**Addendum No. 1**

RE: Contract ID C203082

**Johnston County (B-4558)**

Bridge #86 Over Stoney Fork Creek On SR-1330

PROJECT REFERENCE NO.	SHEET NO.
B-4558	UC-4
DESIGNED BY: NSH	
DRAWN BY: NSH	
CHECKED BY: CDB	
APPROVED BY: CDB	
REVISED:	NORTH CAROLINA DEPARTMENT OF TRANSPORTATION
UTILITIES ENGINEERING SEC. PHONE: (919) 707-6690 FAX: (919) 250-4151	UTILITY CONSTRUCTION PLANS ONLY

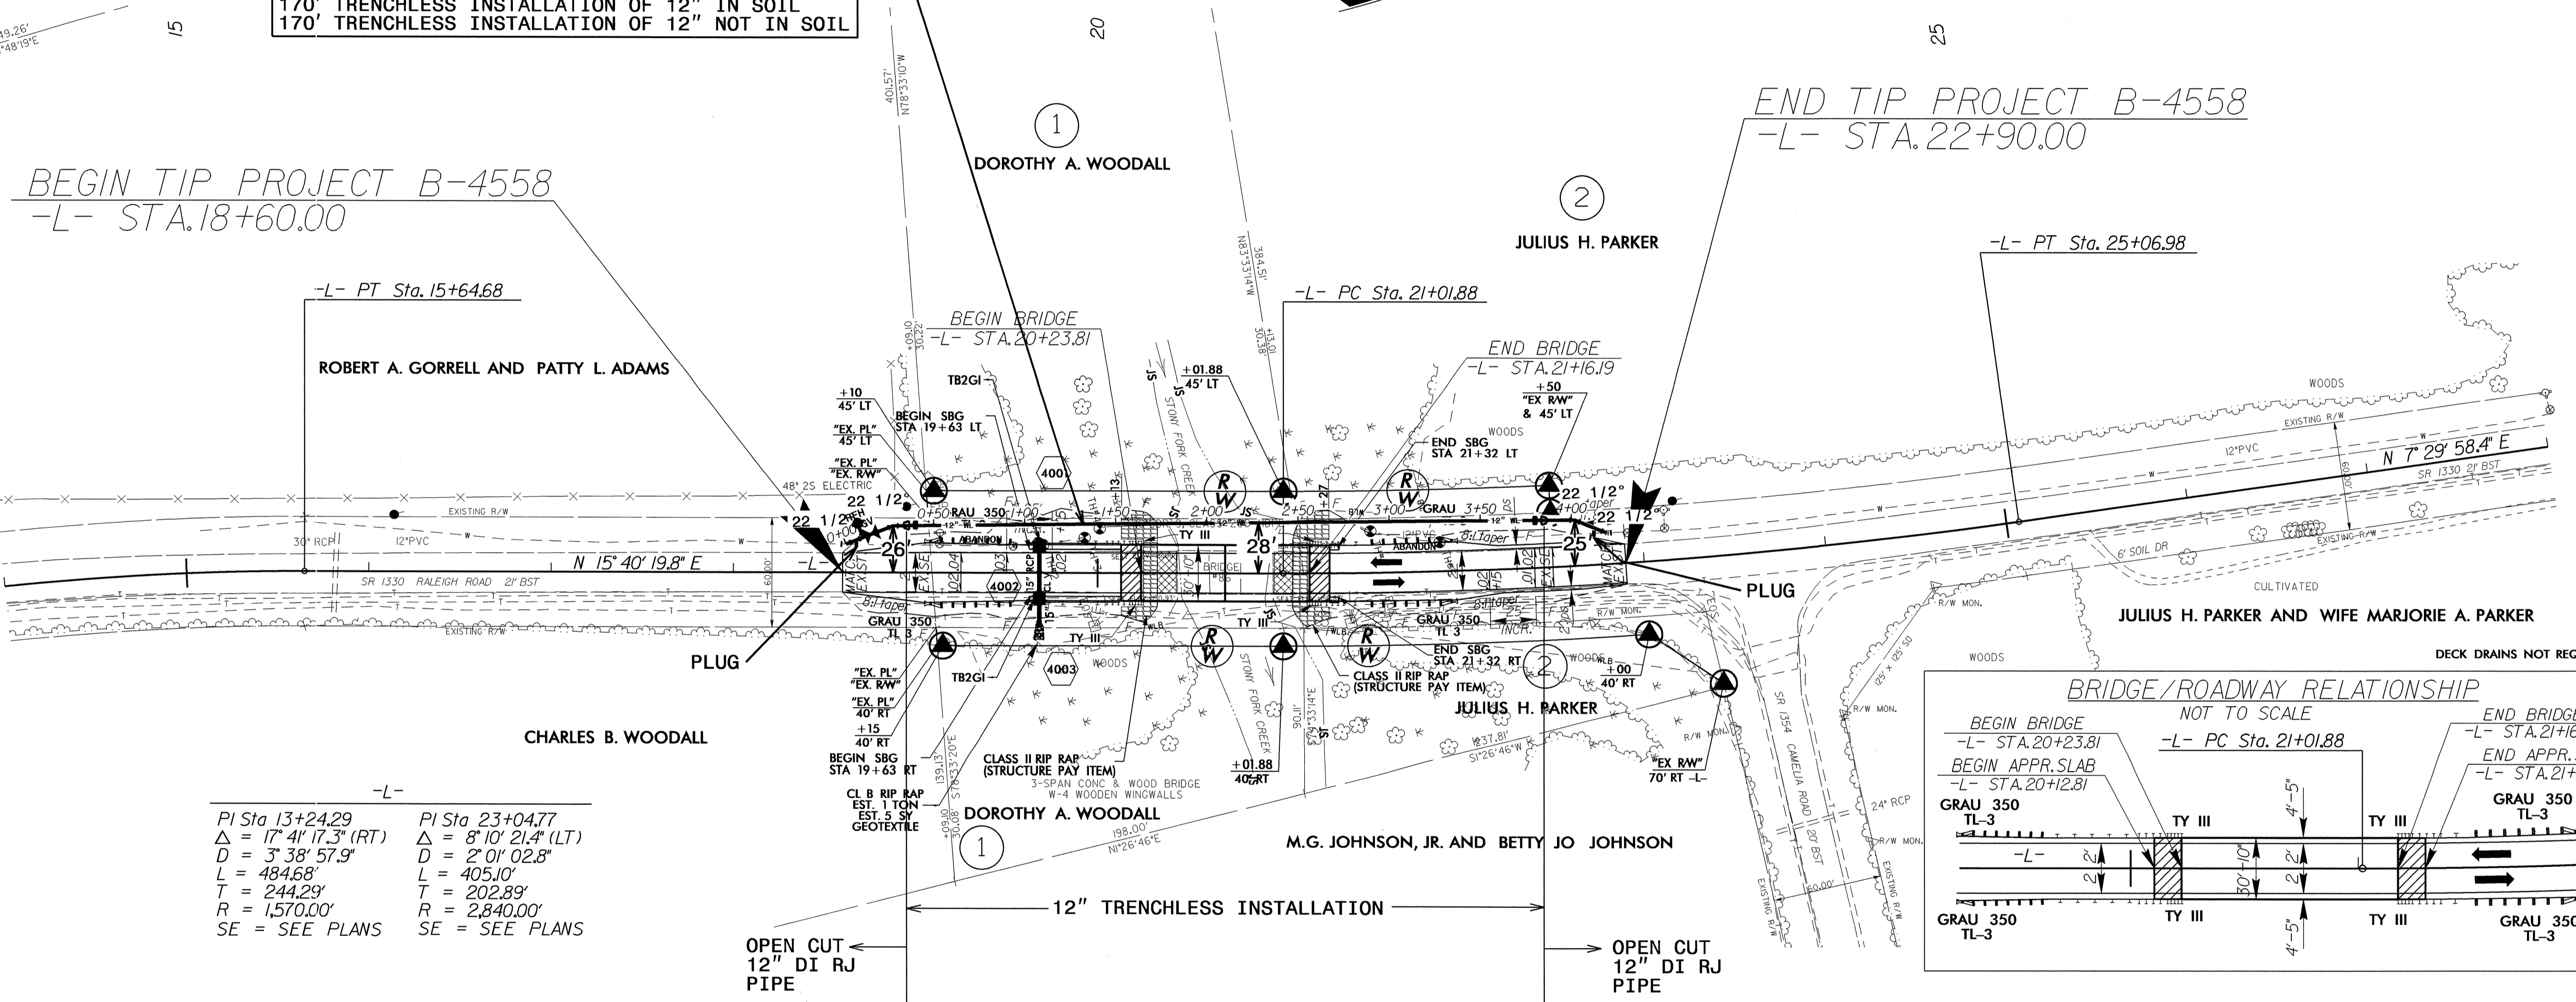
Sheet Nos. UC-4 and UC-5 have been revised to change the location of the fire hydrant and valve. Please void Sheet Nos. UC-4 and UC-5 in your plans and staple the revised Sheet Nos. UC-4 and UC-5 thereto.
